From: Sue Field
Sent: 07 June 2023 12:49
To: Planning.Responses
Subject: FW: WA/56/22/PL Land East of Fontwell Avenue - Variation of condition to provide 5 affordable units above approved shop.
Attachments: 4736-DAN-RET-03.pdf; 4736-DAN-RET-04H.pdf; 4736-DAN-RET-06F.pdf; 4736-DAN-RET-07D.pdf

Elevations Block A - 4736/DAN/RET/04G with attached revision H
Site Plan - 4736/DAN/RET/06E with attached revision F
Ground Floor and Site Layout - 4736/DAN/RET/07C with attached revision D

Drawing No: 4736/DAN/RET/06F

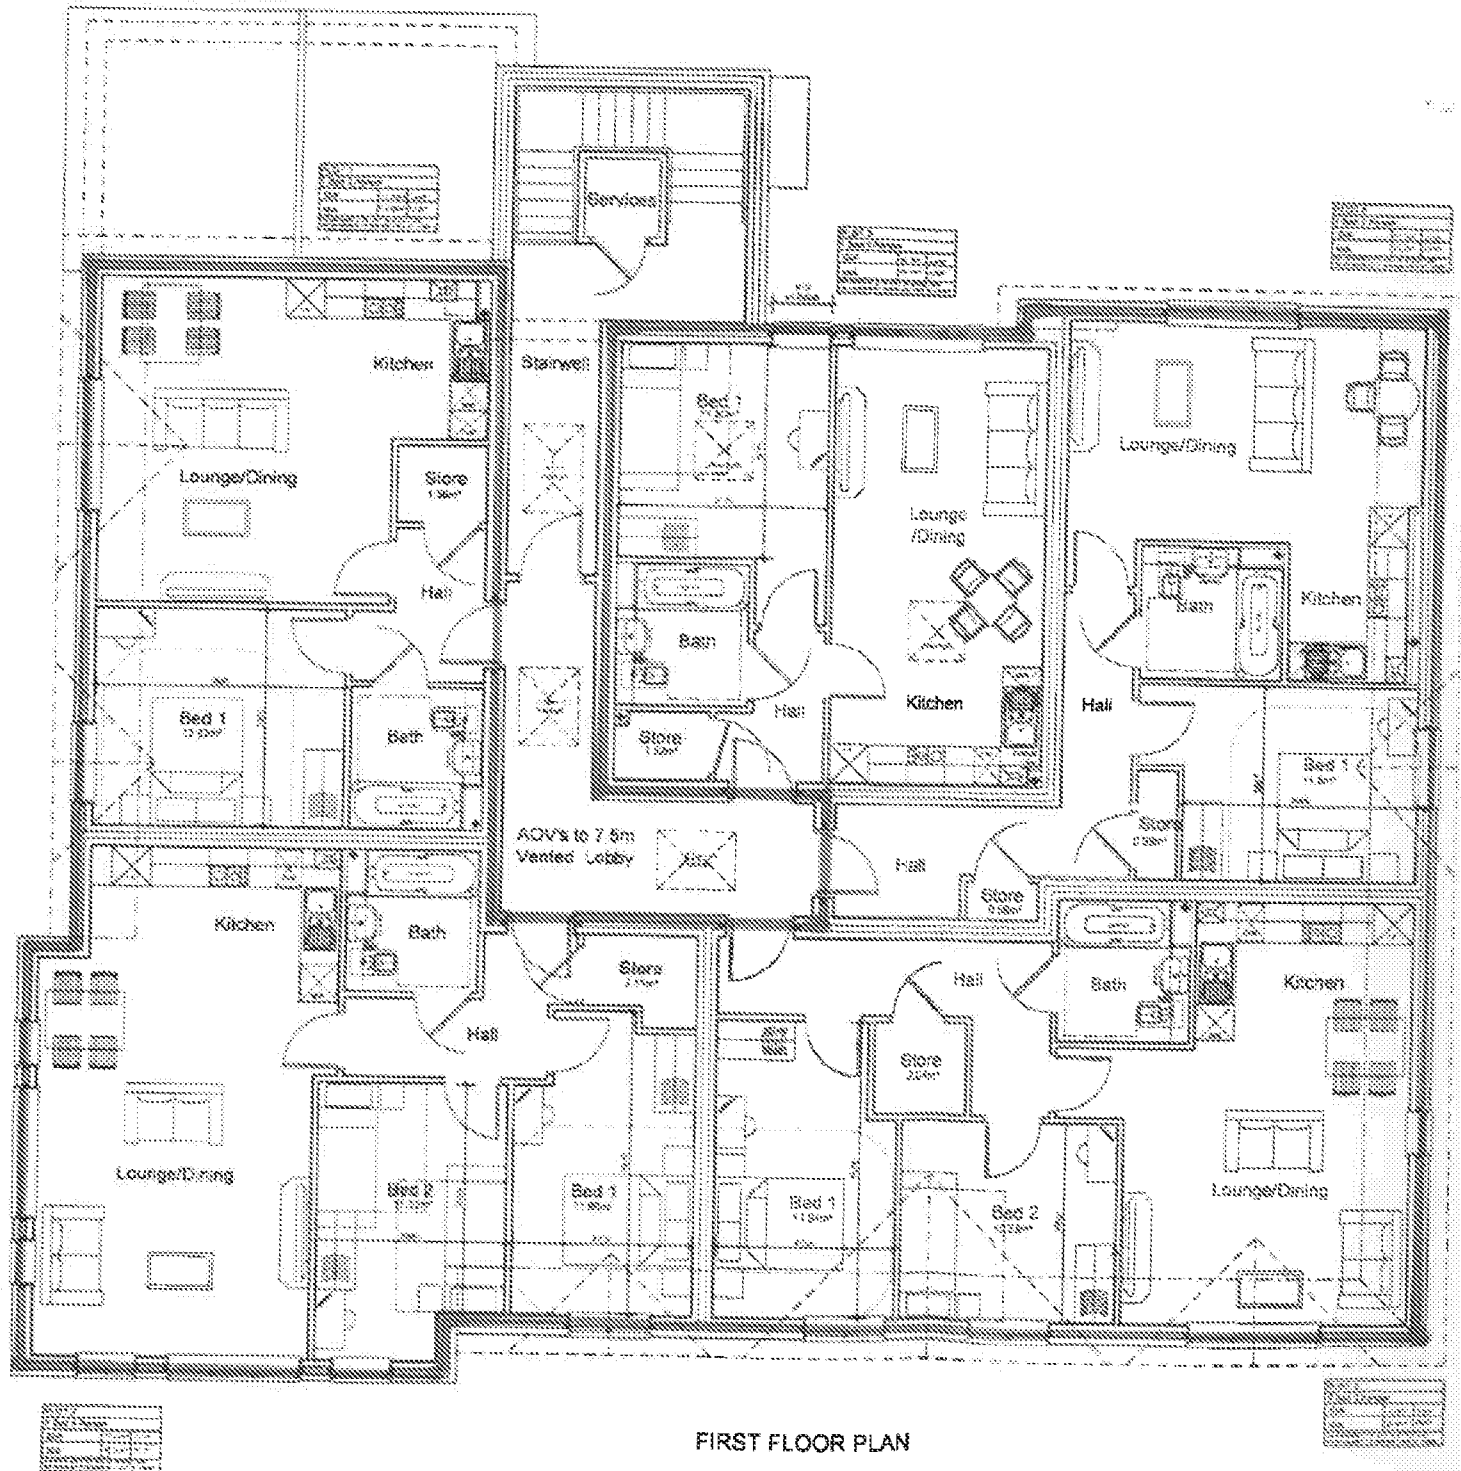
The residential cycle parking should be covered / secure. A fenced solution wouldn't be appropriate in this situation. (also does not appear to have a roof)

Please find attached a further set of revised drawings detailing the covered cycle store and showing it on the elevations.

Date: FEB 23	Scales: 1:100 @ A1
Drawn: CA	Checked: Approved:
Drawing No.	4736/DAN/RET/06E

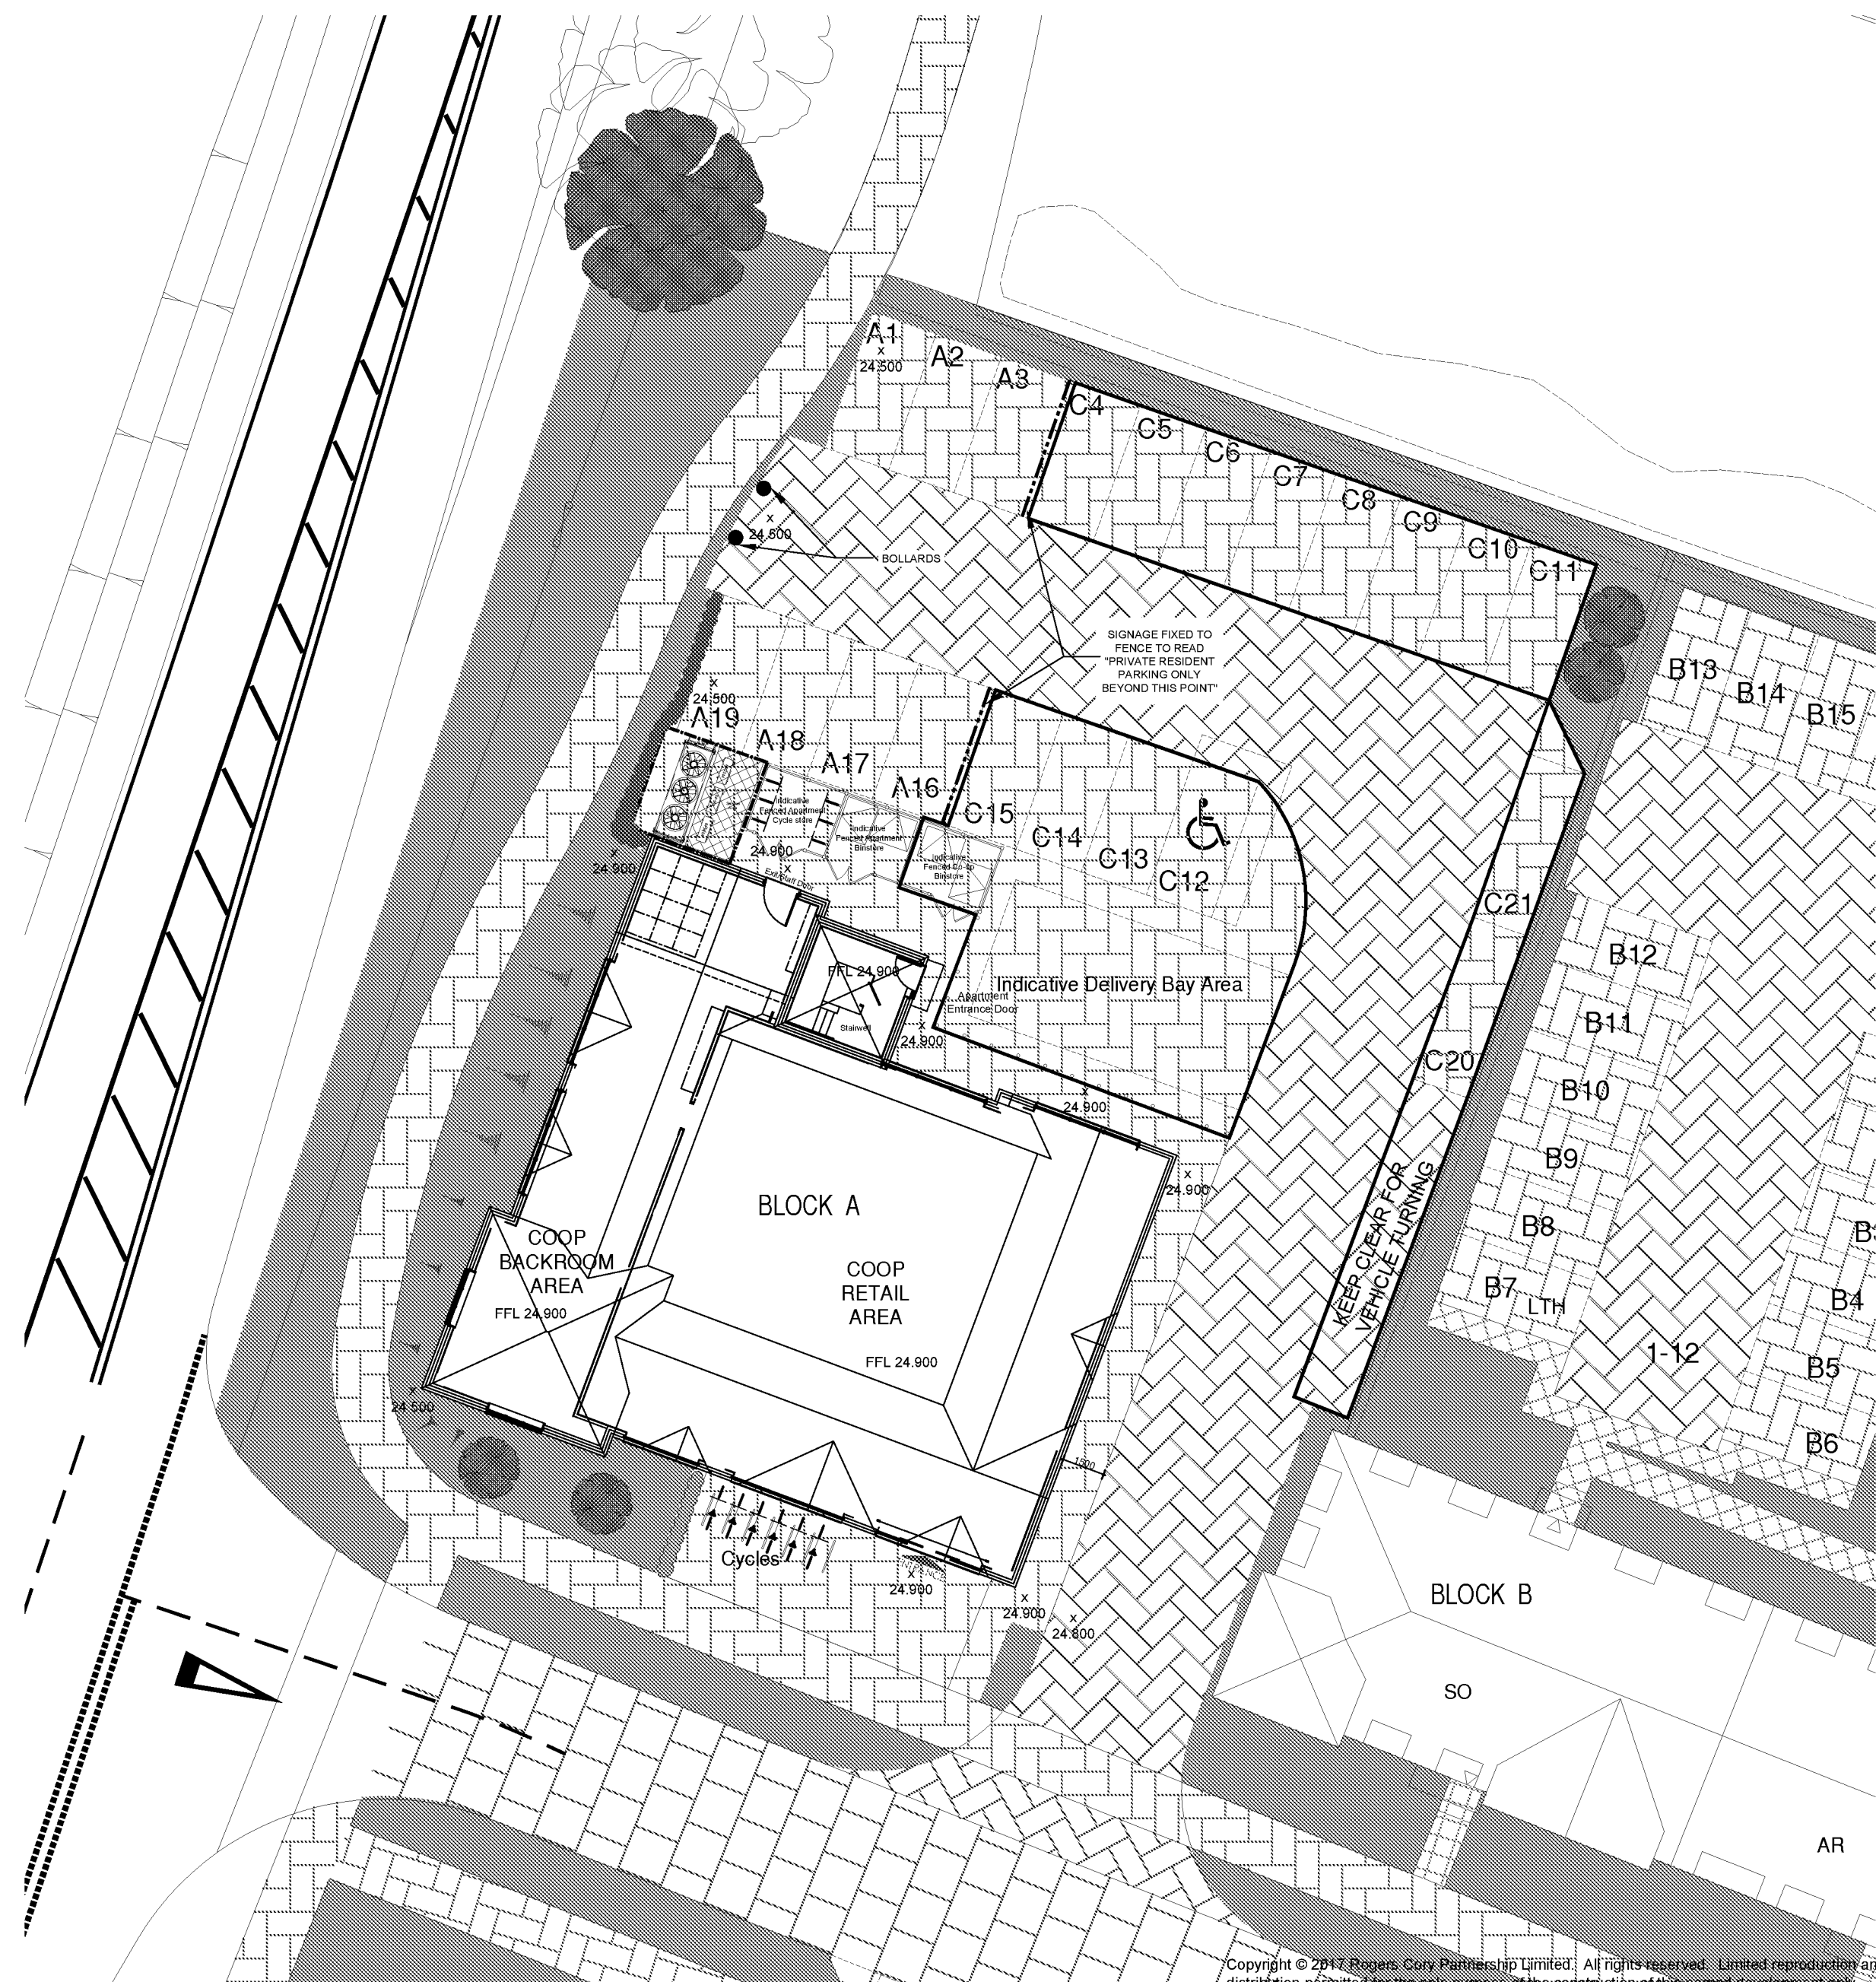
Please could you update the plans to reflect his comments in regard to covered and secure cycle parking for the residential units.

Finally, on the issue of the covered cycle parking, we will be submitted a revised plan show the cycle spaces are to be covered.
